MEMORANDUM

TO: Jean Fraser, Planner
FROM: David Senus, P.E.
DATE: April 22, 2015
RE: 1342 Congress Street Neighborhood Center, Preliminary Level III Site Plan Application

Woodard & Curran has reviewed the Preliminary Level III Site Plan Application for the proposed Neighborhood Center located at 1342 Congress Street in Portland, Maine. The project involves the construction of a 19,300 SF building with associated site improvements that include a surface parking lot, stormwater management system, utilities, site lighting, and landscaping. The project will disturb approximately 85,000 SF and result in 12,500 SF of additional impervious area.

- Preliminary Level III Site Plan Application and attachments, dated April 3, 2015, prepared by Tighe & Bond, on behalf of the Jewish Community Alliance of Southern Maine.
- Engineering Plans, Sheets C-1 through C-9, dated April 3, 2015, prepared by Tighe & Bond, on behalf of the Jewish Community Alliance of Southern Maine.

GRADING, DRAINAGE, AND EROSION CONTROL PLAN

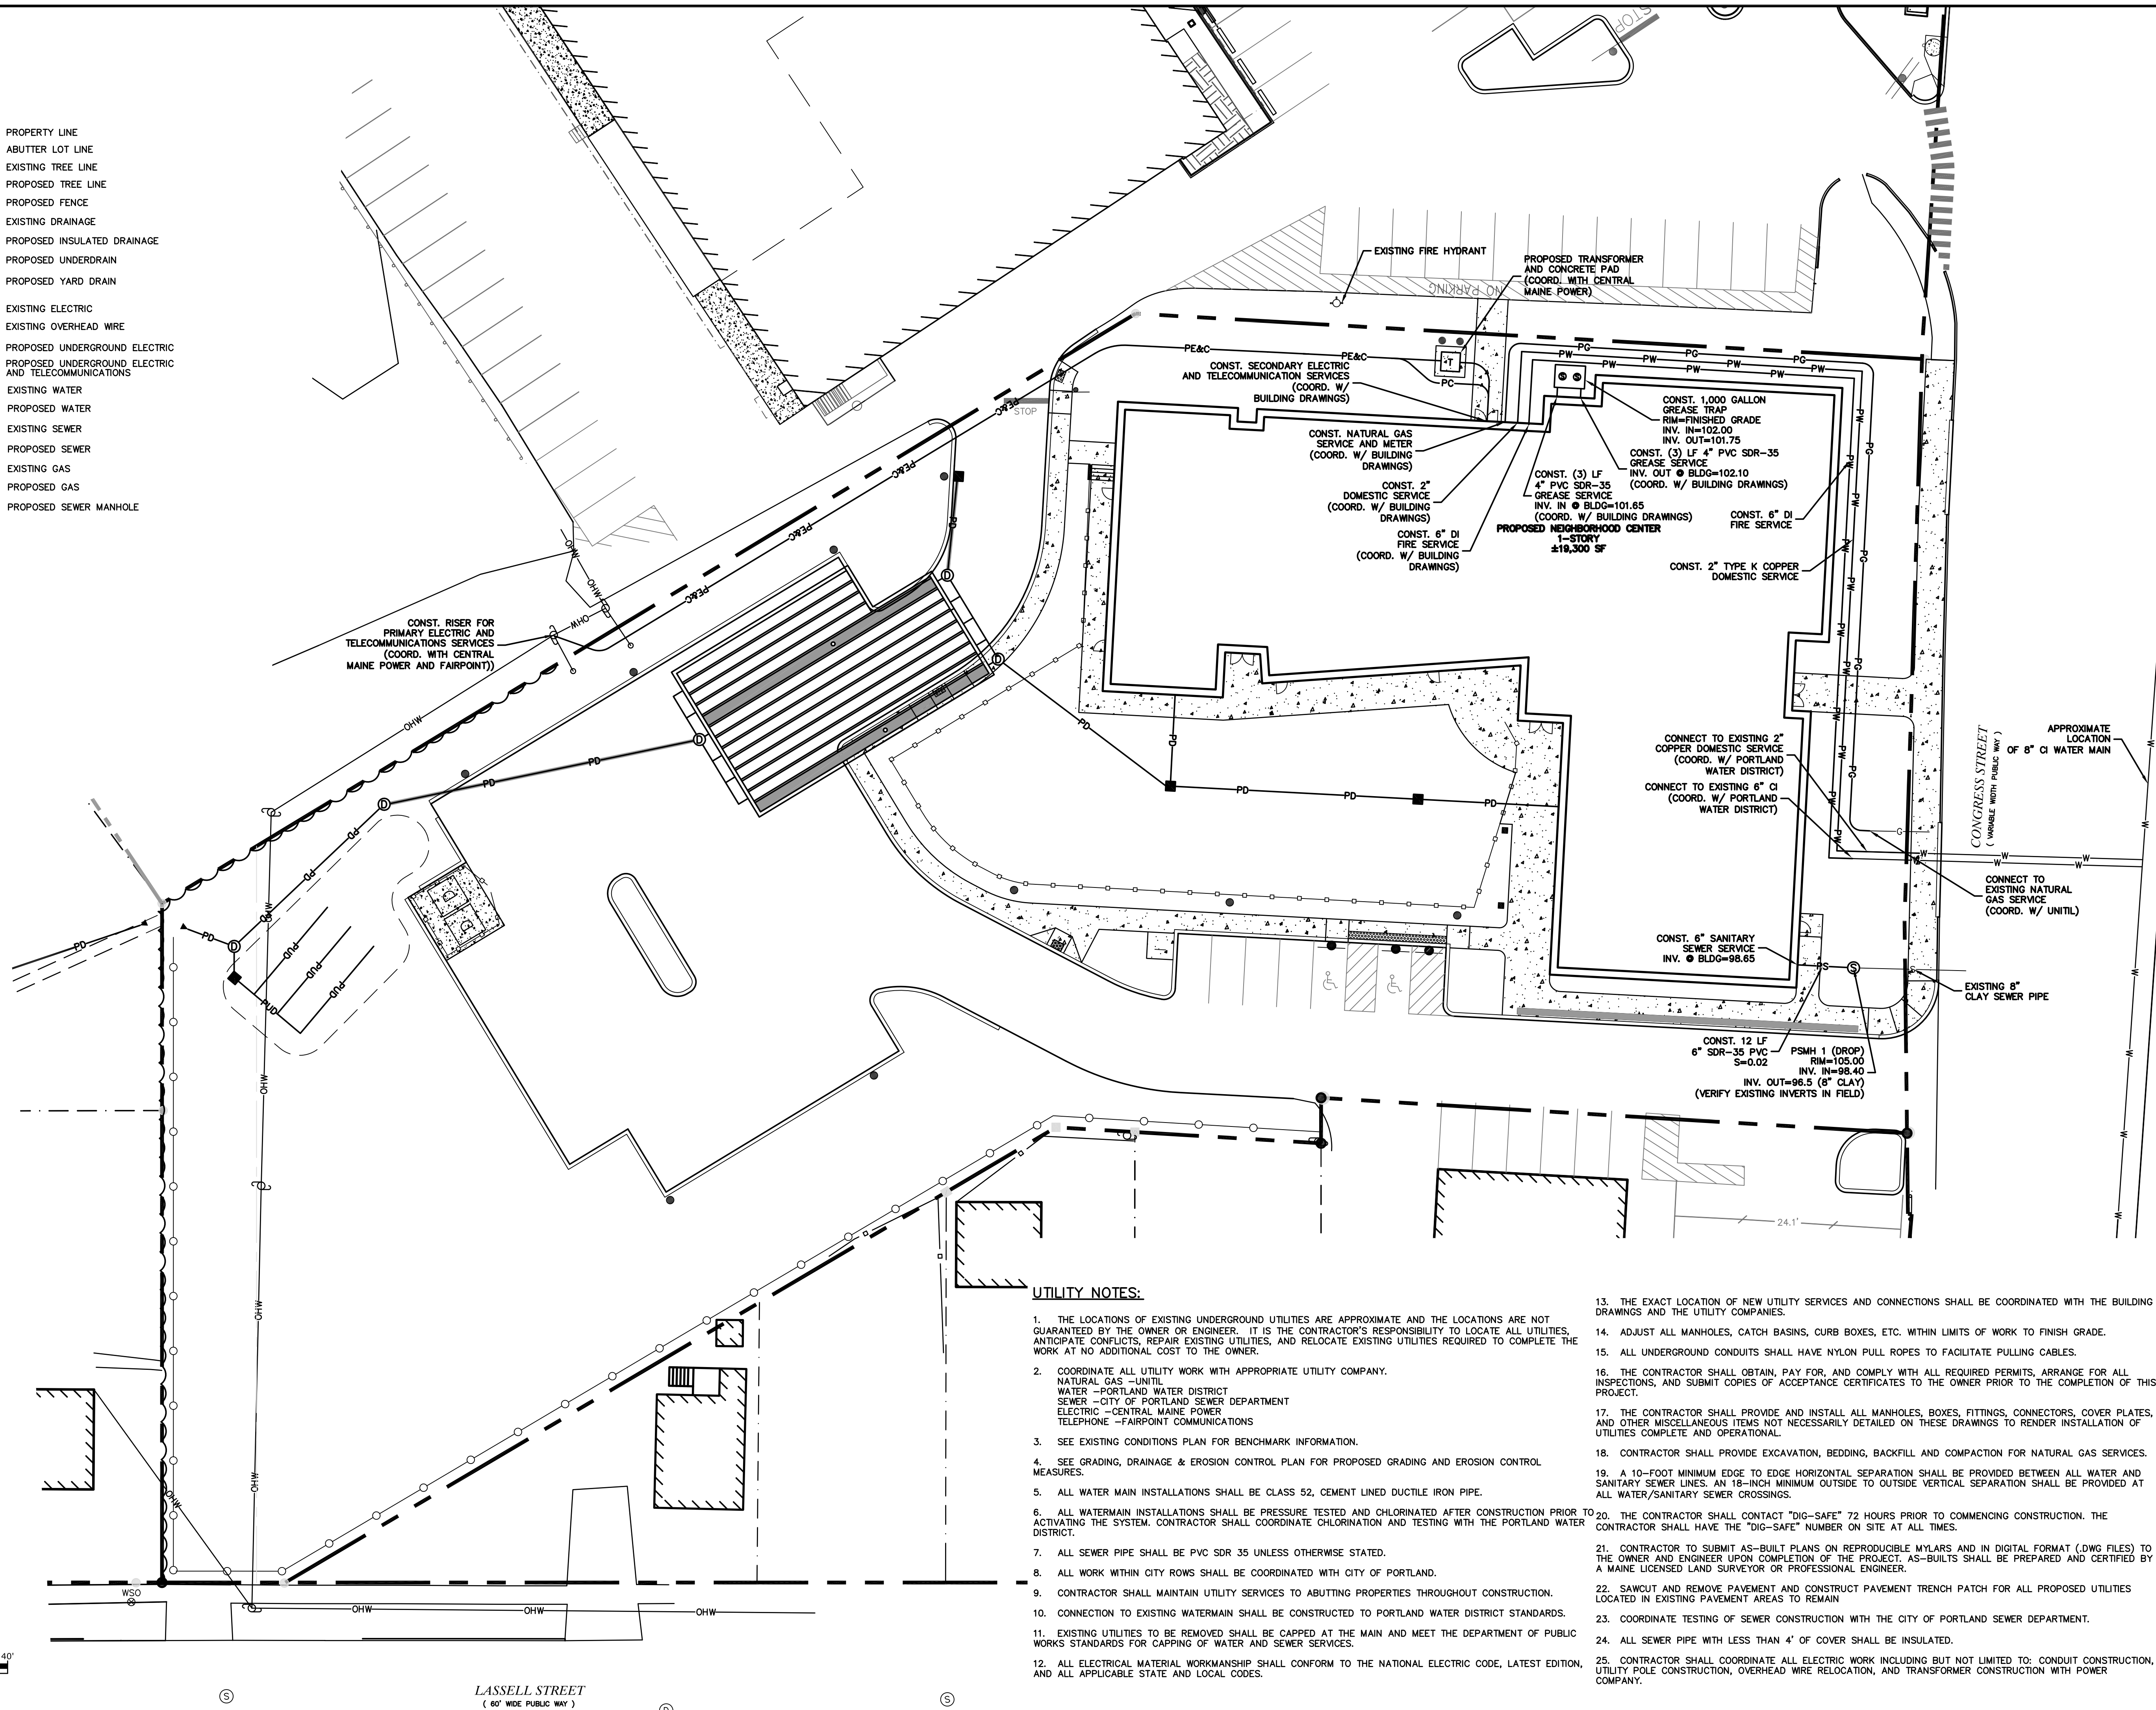
- v) The Applicant has proposed to discharge the majority of the site's drainage to a new outfall located at the southwest edge of the site, adjacent to an existing drainage ditch that flows across a residential property located south of the site. Although the pre/post stormwater analysis is intended to show that the flow at this study point will not increase in the 2, 10 and 25 year storm event conditions, there will be a new outfall with a concentrated discharge at this location. We recommend that the Applicant work with the adjacent property owner to determine if there are existing concerns over drainage in this area, and based on input from that property owner, determine if improvements can or should be made to the drainage ditch as part of this project.

VERTICAL GRANITE CURB
NOT TO SCALE

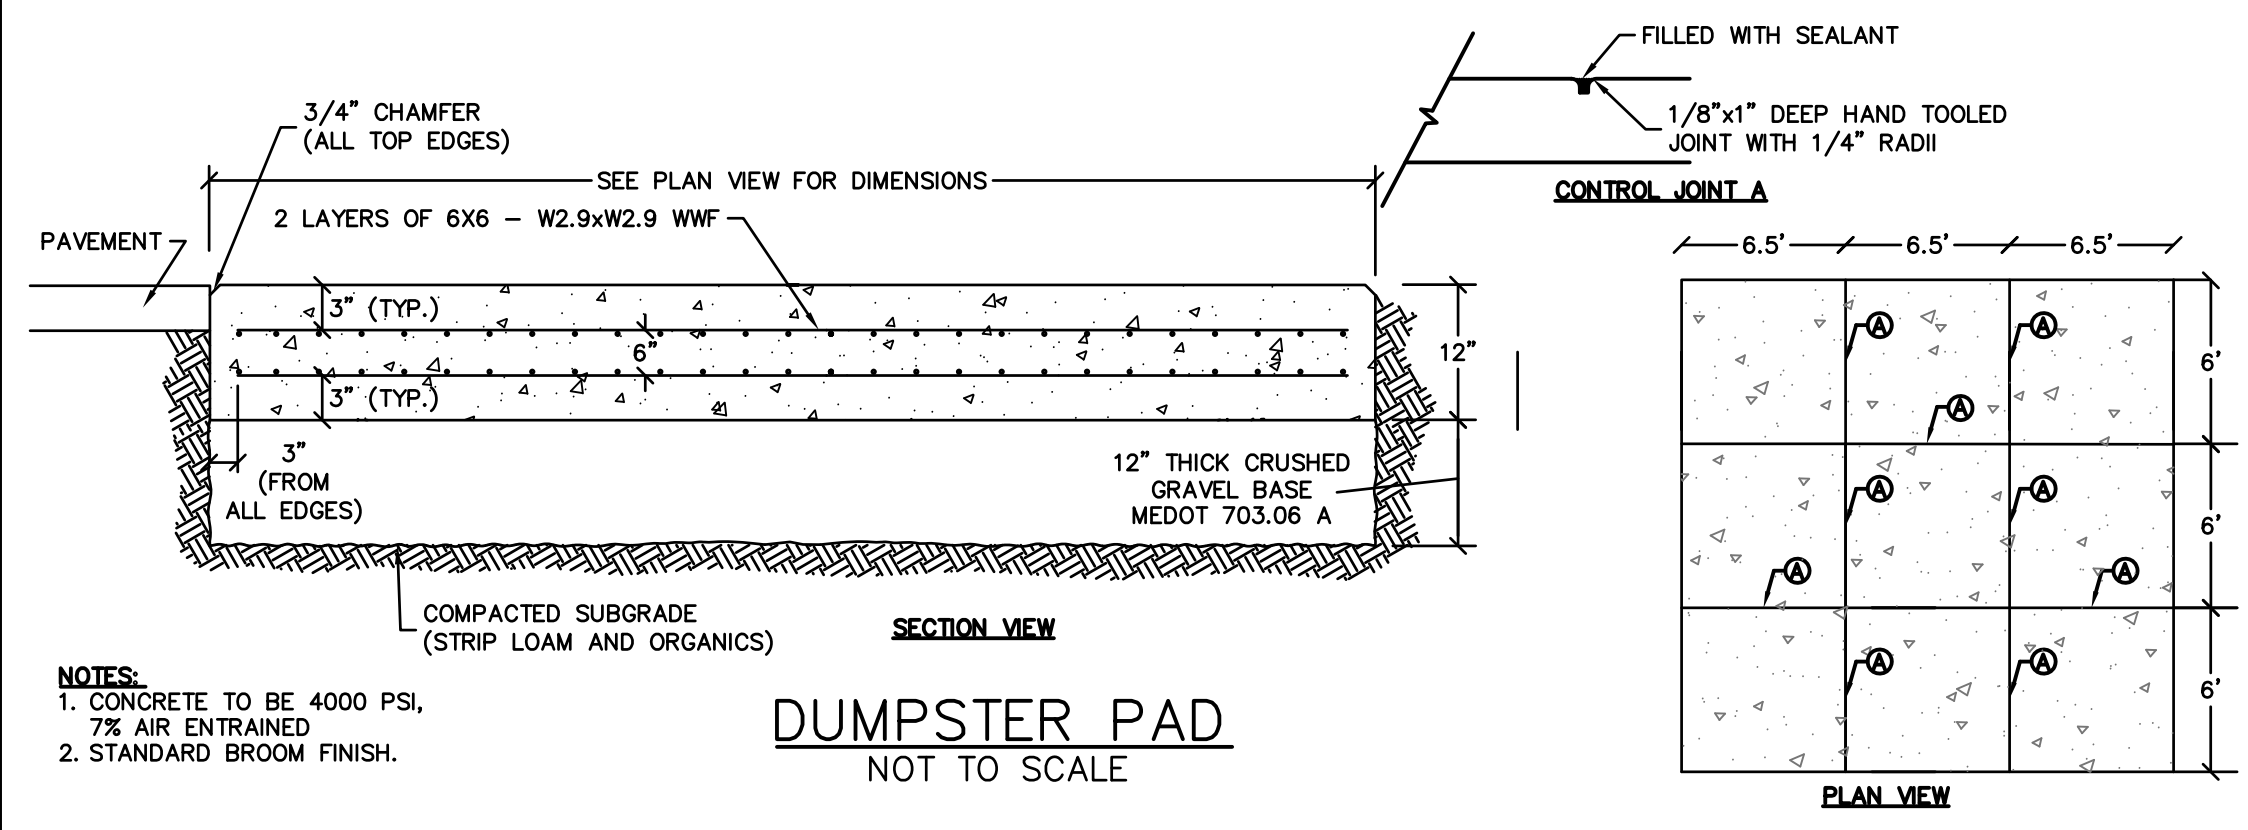
- 6) The proposed Vertical Granite Curb, Concrete Sidewalk, and Utility Trench details should be revised to comply with the City of Portland Technical Manual for work within the City Right-of-Way.

CROSS SECTION UNDERDRAINED SOIL FILTER
DETAIL
NOT TO SCALE

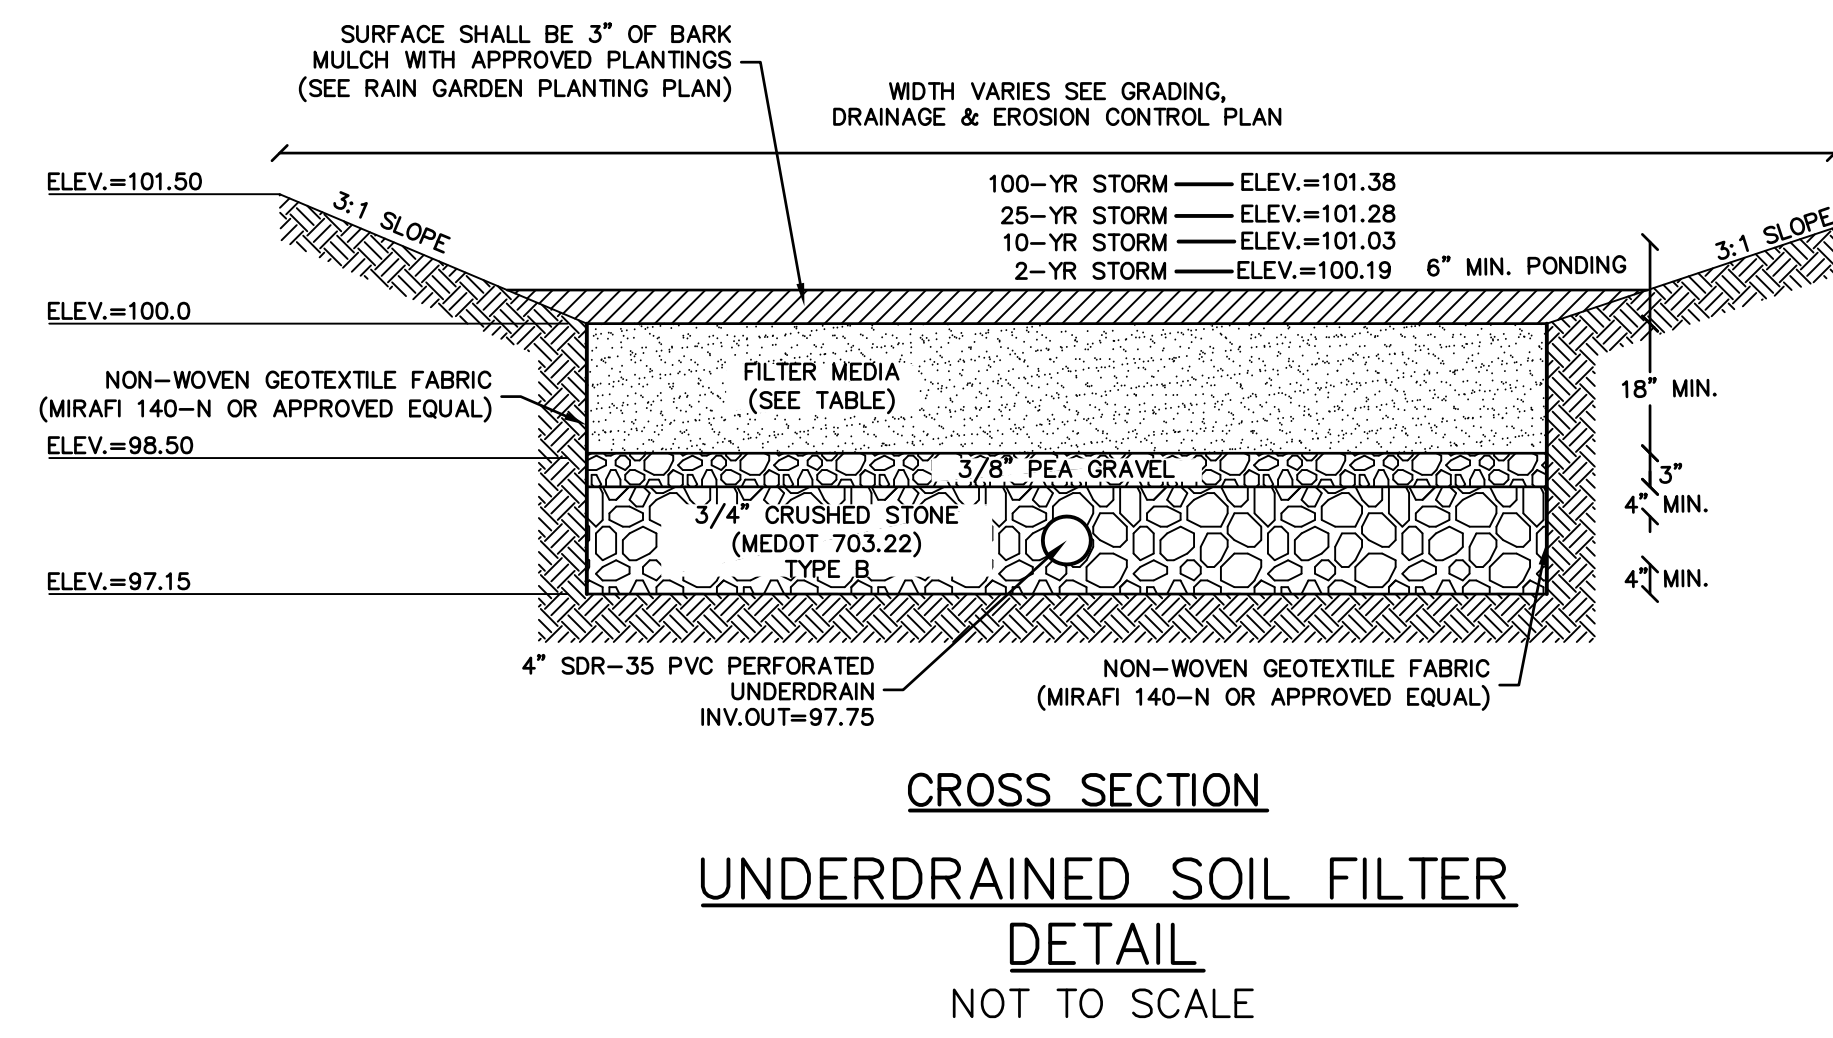
- i) The Applicant has requested a waiver from the requirement for pre-treatment of runoff directed to filter BMPs due to topographic and geometric constraints of the site. Pre-treatment is particularly important for filter systems to ensure that sediment does not clog the filter and impede its function. It appears that there is ample space on the southern portion of the site to provide the MaineDEP recommended forebay area. We recommend that the applicant include a sediment forebay at the inlet point to the filter.

- 5) The proposed Underdrained Soil Filter Bed detail refers to a Rain Garden Planting Plan for proposed plantings; however, it does not appear that this plan has been provided at this time.
